**Consultation Response from KC,
 Policy**
2024/90292 Springfield Barn, Fieldhead Lane, Holme, Holmfirth, HD9 2QJ
Formation of practice arena
Date Responded:
Responding Officer:
Responding Ref:

This application is for the formation of a practice arena at Springfield Barn, Fieldhead Lane, Holme, Holmfirth, HD9 2QJ. The application site is in the green belt, therefore Green Belt policies in the National Planning Policy Framework (NPPF) and the Kirklees Local Plan apply.

Section A-A as Existing

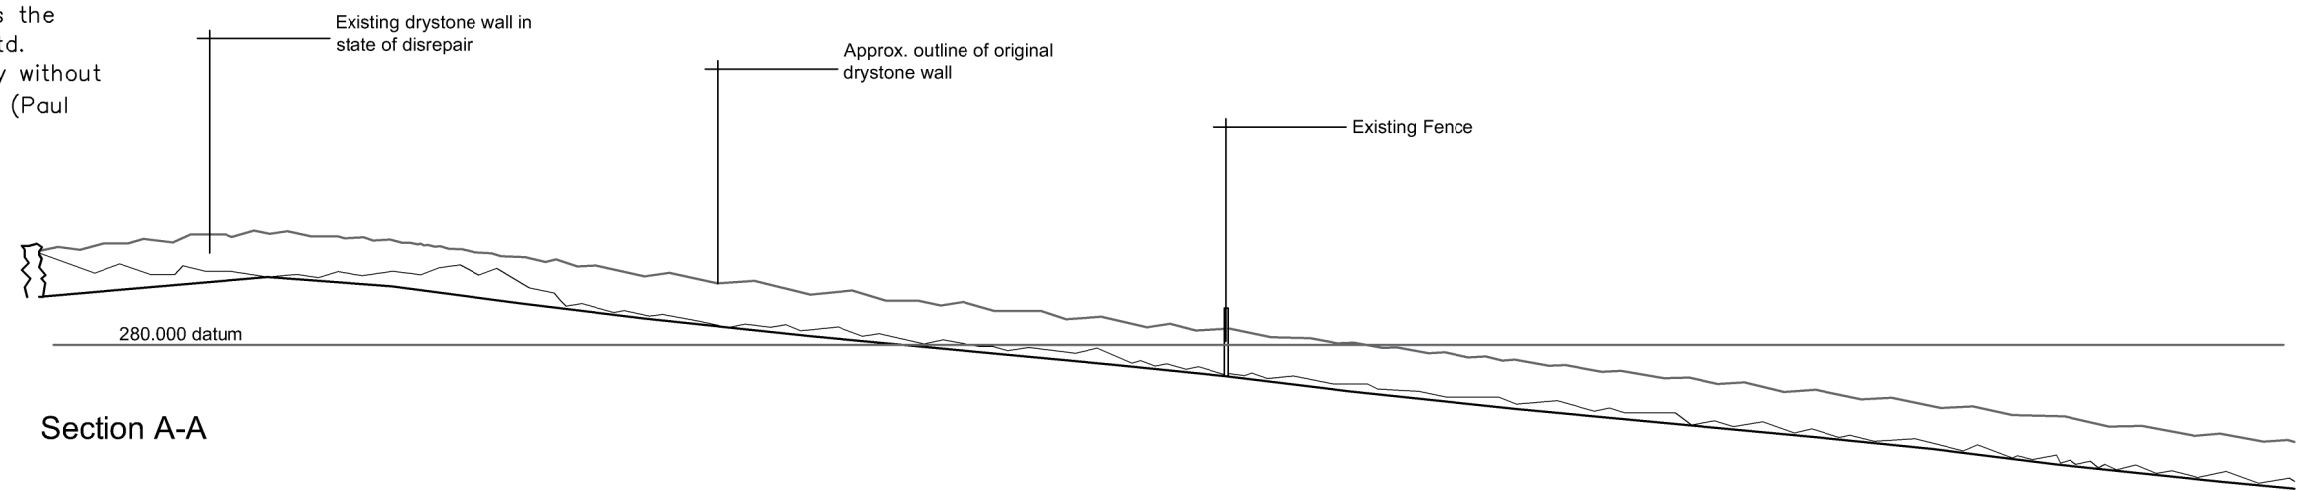
Giving regard finally to criteria c), the site which would host the proposed arena slopes down from Fieldhead Lane, and a significant degree of re-grading would be required in order to provide an appropriate flat surface. The degree of engineering operations required to form the facility, and the resultant re-grading of land, would result in a discordant landform out of character with its setting, contrary to the wording in policy LP56c). Such engineering operations would alter the land to appear out of character with the wider setting, and while it may be possible to mitigate the impact through landscaping, the planting itself may also be out of keeping with this open upland landscape, and could inflict further harm upon the openness of the green belt. Significant consideration must also be given in this case to the fact that the site to which this application relates is situated in a highly sensitive setting, directly adjoining land within the Peak District National Park. With this in mind, the proposal would fail to accord with criteria c) of policy LP56, and paragraphs 154b) and 155b) of the NPPF, and would therefore constitute inappropriate development in the green belt.
